A/38/18/RES

Martyn White | Principal Conservation Officer, Planning Policy, Directorate of Place, Arun District Council | Location: First Floor, Arun Civic Centre, Maltravers Road, Littlehampton, BN17 5LF

APPENDIX 3
TREE RETENTION / REMOVAL PLAN
Indicating proposed re-planting
and proposed tree protection measures.

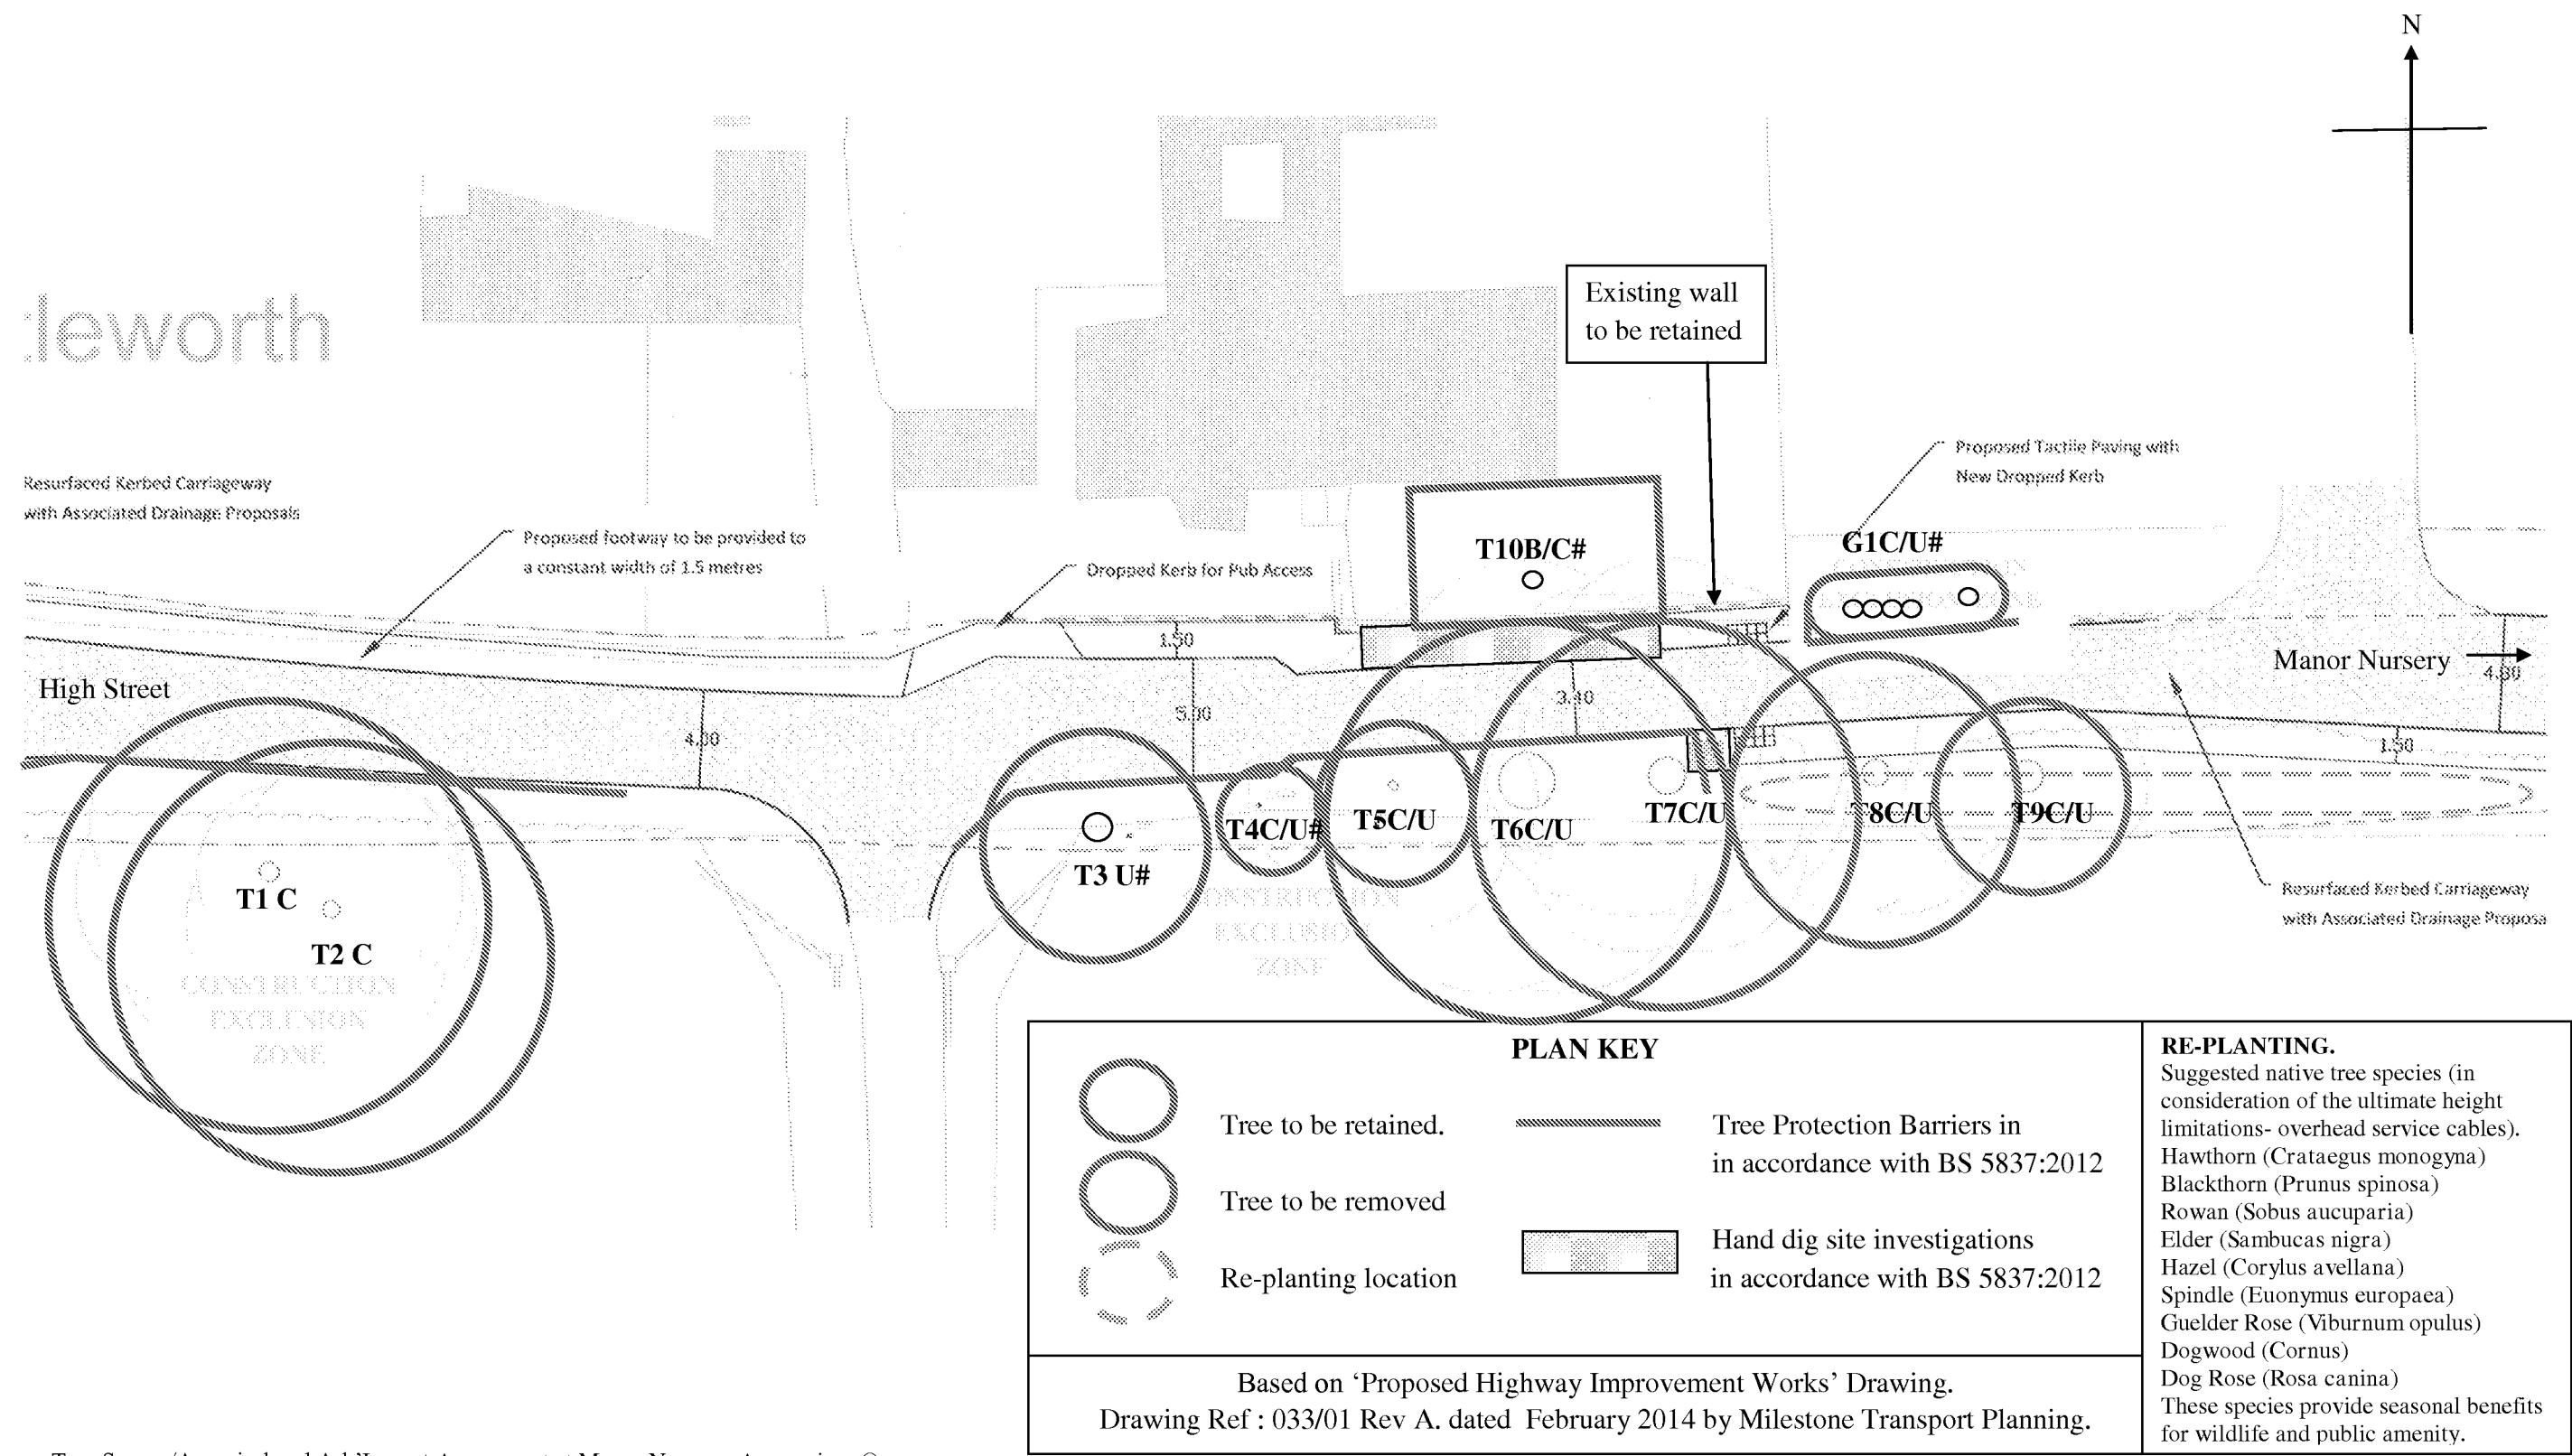
The development proposes to locate the public open space closest to the street and would potentially be visible from the Conservation Area. This is especially true with the removal of the existing boundary treatment (as identified on the Tree retention and protection plan 03).
